EL PASO COUNTY PLANNING AND COMMUNITY DEVELOPMENT DEPARTMENT

GRADING AND EROSION CONTROL PLAN CHECKLIST

Revised: July 2019

C1

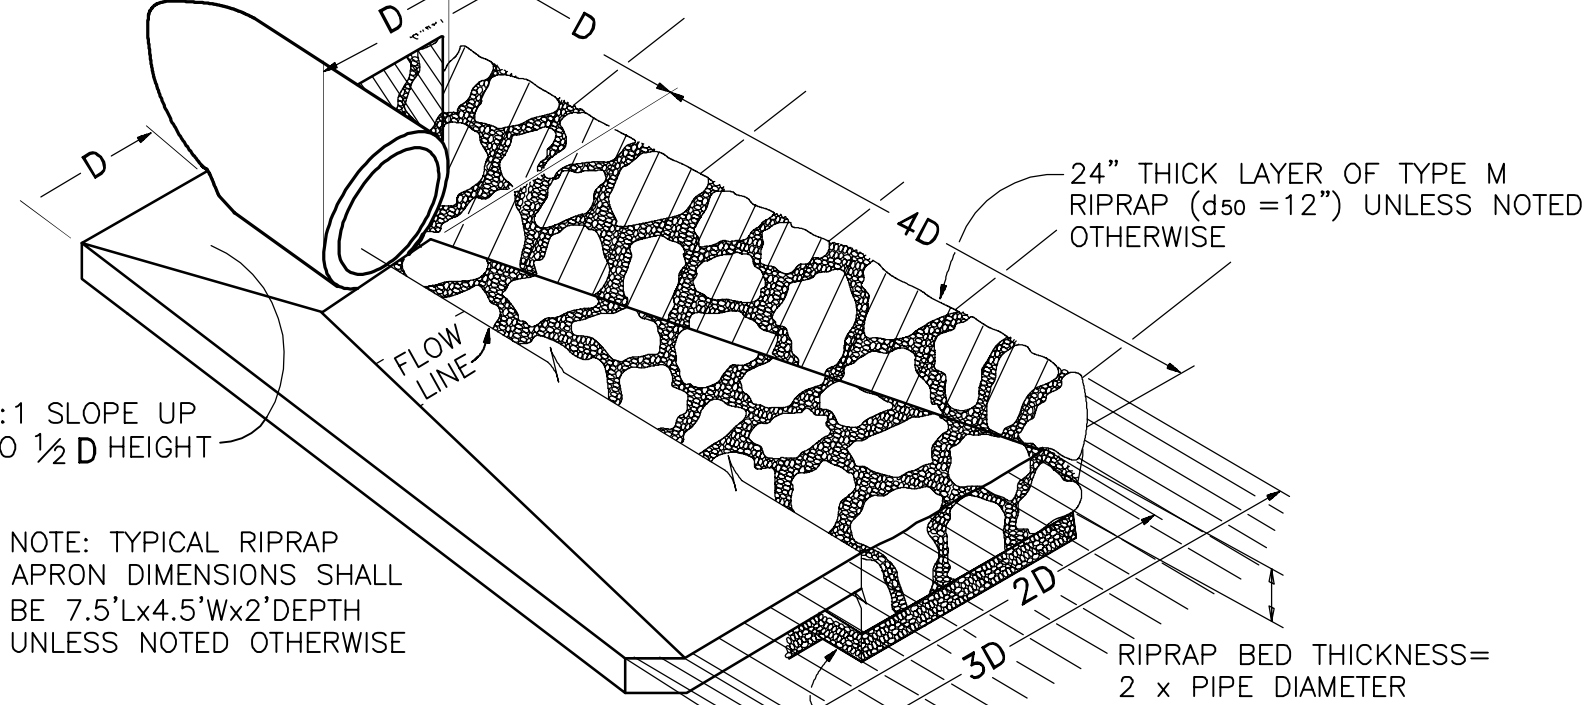
l	Existing and proposed contours 2 feet or less (except for hillside).	Y	Y
m	Limits of disturbance delineating all anticipated areas of soil disturbance. See my comment on sheet C1	Y	
n	Identify and protect areas outside of the construction site boundary with existing fencing, construction fencing or other methods as appropriate.	Y	Y
o	Offsite grading clearly shown and called out. See my comment on sheet C1	Y	
p	Areas of cut and fill identified. See my comment on sheet C1	Y	
q	Conclusions from soils/geotechnical report and geologic hazards report incorporated in grading design (slopes, embankments, materials, mitigation, etc.)	Y	Y
r	Proposed slopes steeper than 3:1 with top and toe of slope delineated. Erosion control blanketing or other protective covering required.	NA	N/A
s	Stormwater flow direction arrows.	Y	Y
t	Location of any dedicated asphalt / concrete batch plants.	NA	N/A
u	Areas used for staging, storage of building materials, soils (stockpiles) or wastes. The use of construction office trailers requires PCD permitting.	Y	Y
